Rosefield Solar Farm

Schedule of Changes to the draft DCO (Clean)

EN010158/APP/8.1.6
Revision 06
Deadline 4
June 2026
Rosefield Energyfarm Limited

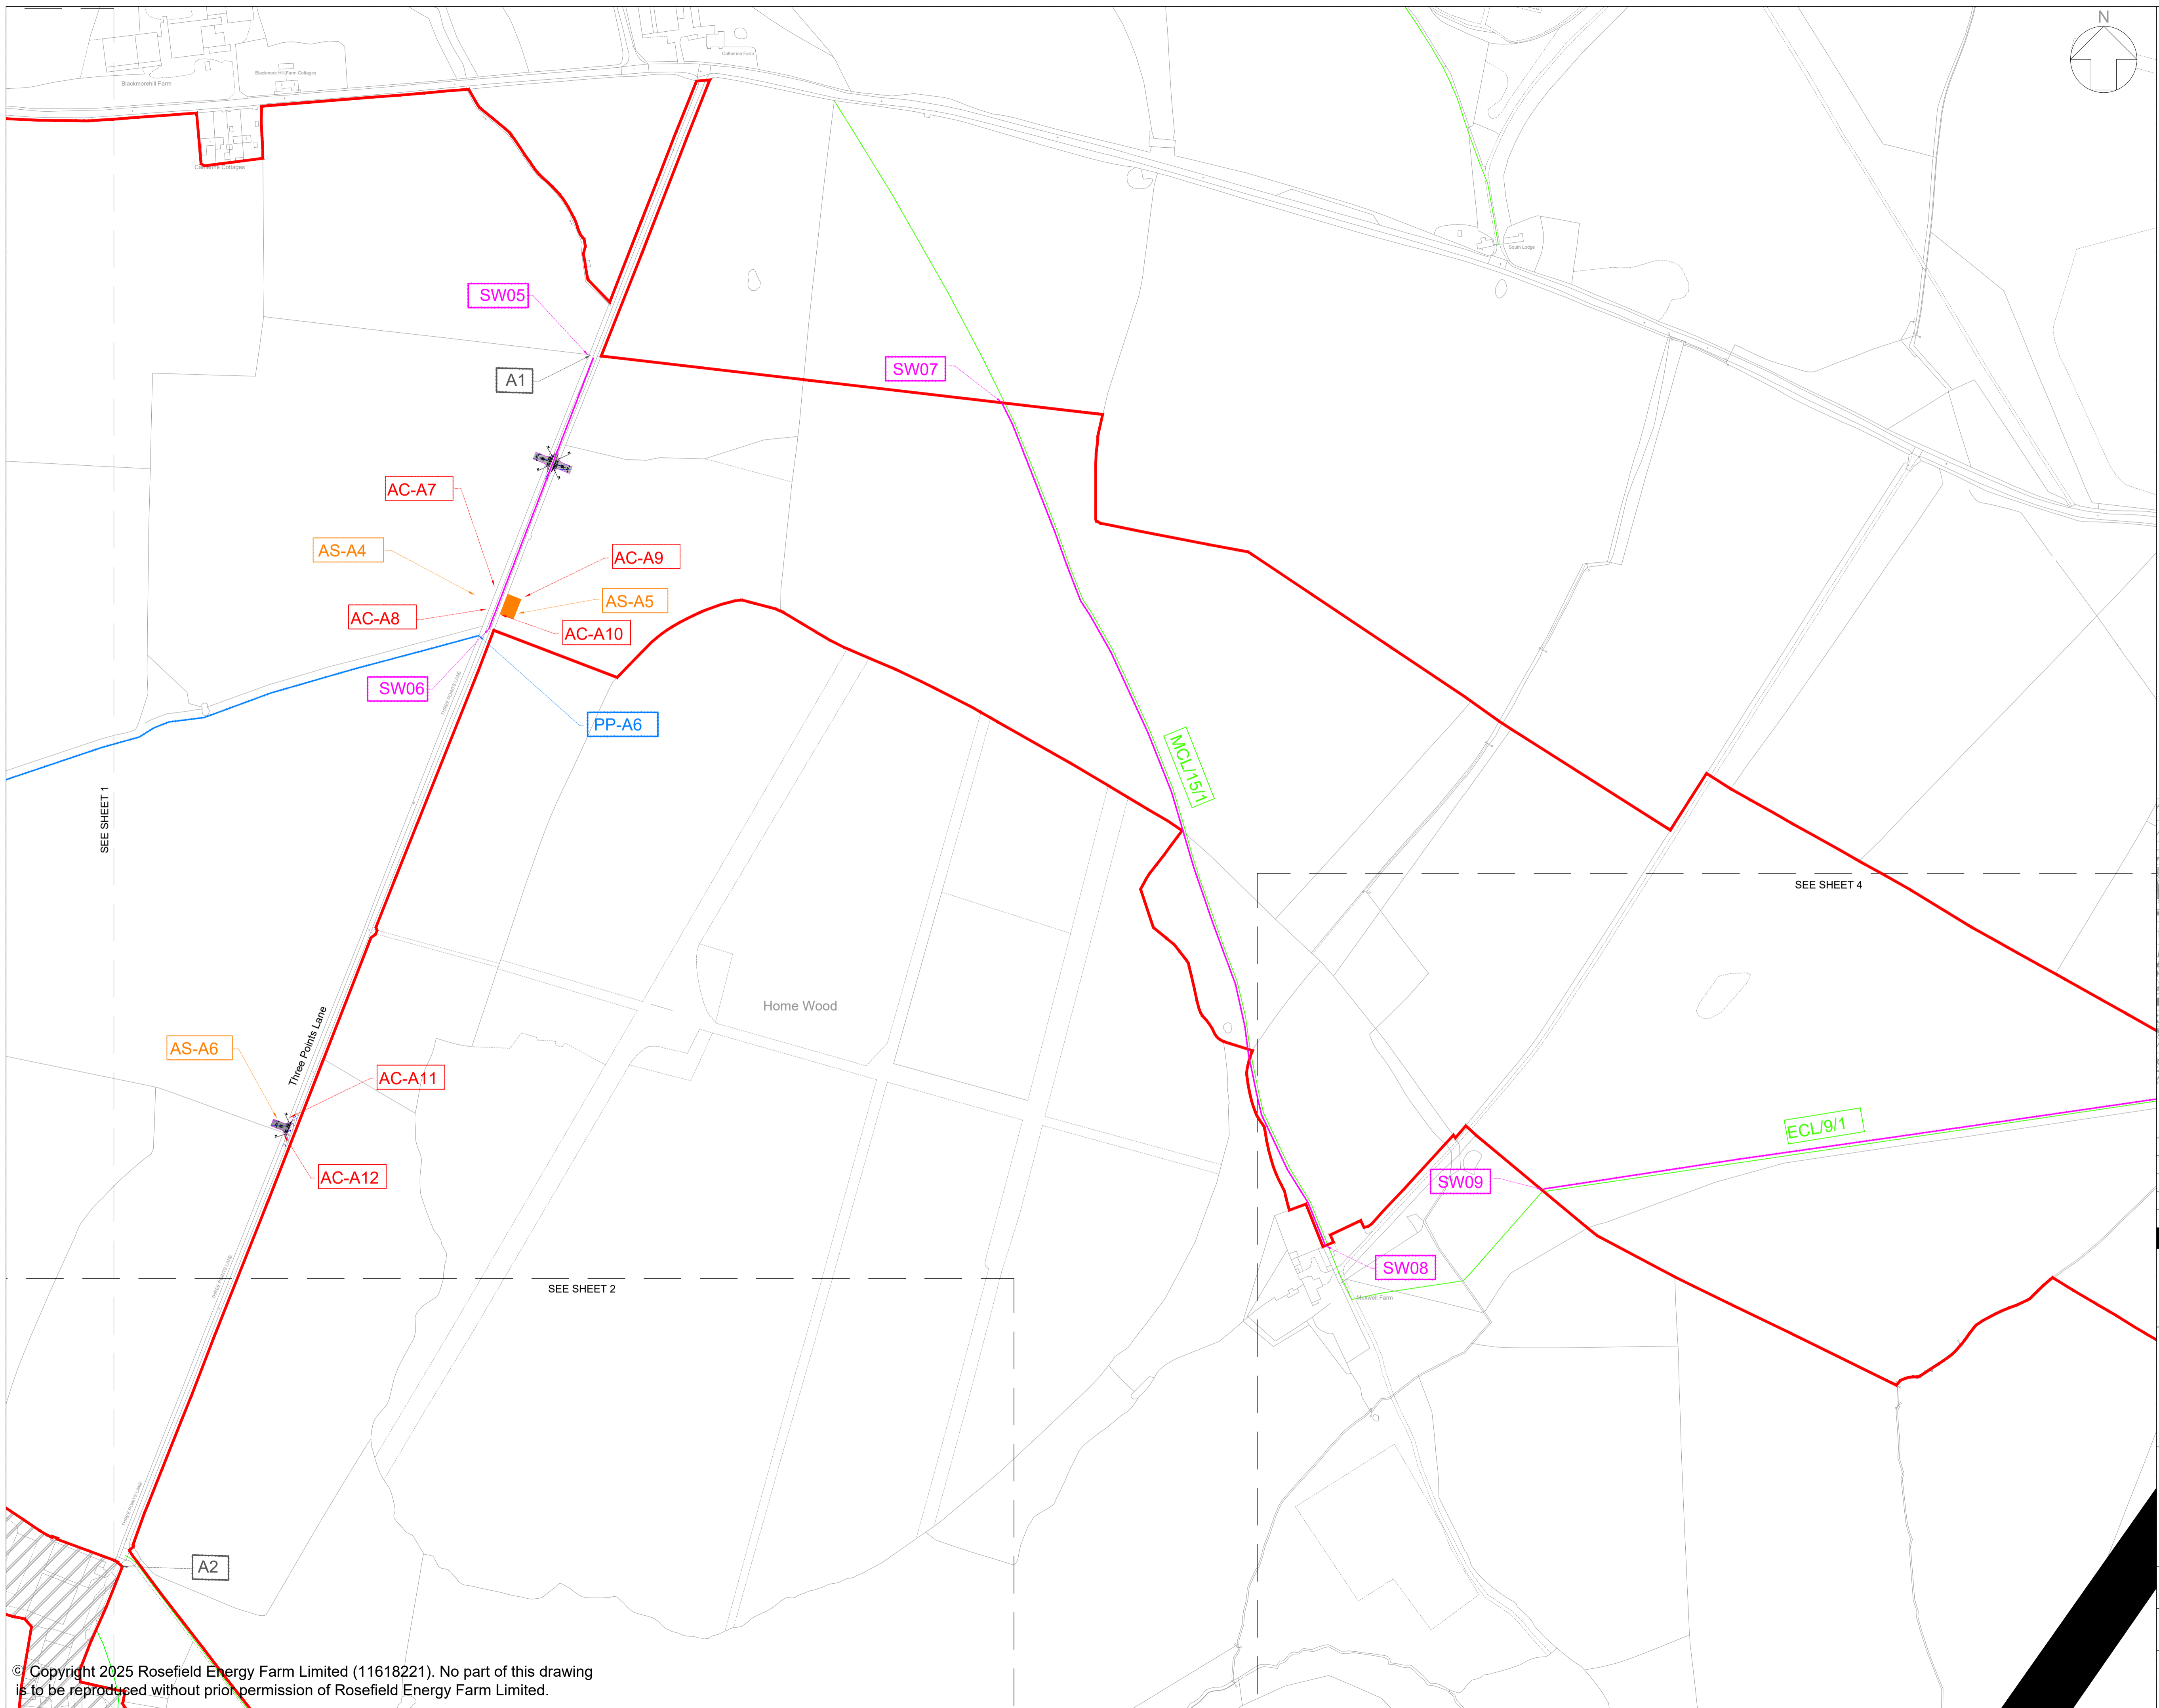
Reference	Change			Reason for Change	Deadline	
	District of Buckinghamshire	ECL/7/2	For a distance of 243 metres between points PE-A1 and PE-A2 as shown on sheet 4 of the streets, access and rights of way plans.	New public footpath of minimum width of 2m to be provided between points PE-A1 and PE-A2 as shown by a cyan line on sheet 4 of the streets, rights of way and access plans.		
	District of Buckinghamshire	ECL/4/2	For a distance of 463 metres between points PE-A8 and PE-A9 as shown on sheet 7 of the streets, access and rights of way plans.	New public footpath of minimum width of 2m to be provided between points PE-A8 and PE-A9 as shown by a cyan line on sheet 7 of the streets, rights of way and access plans.		
<p>Schedule 16, 2(1) (Applications made under requirement)</p>	<p>For an application for discharge of a requirement to be valid, the undertaker must provide the following information to the relevant planning authority electronically via email (unless otherwise agreed between the parties in writing)—</p>			<p>The below updates to Schedule 16 have been made in response to comments in Buckinghamshire Council’s Local Impact Report [REP1-112] and following further engagement with the Council following ISH1. Amendments reflect the approach</p>	<p>4</p>
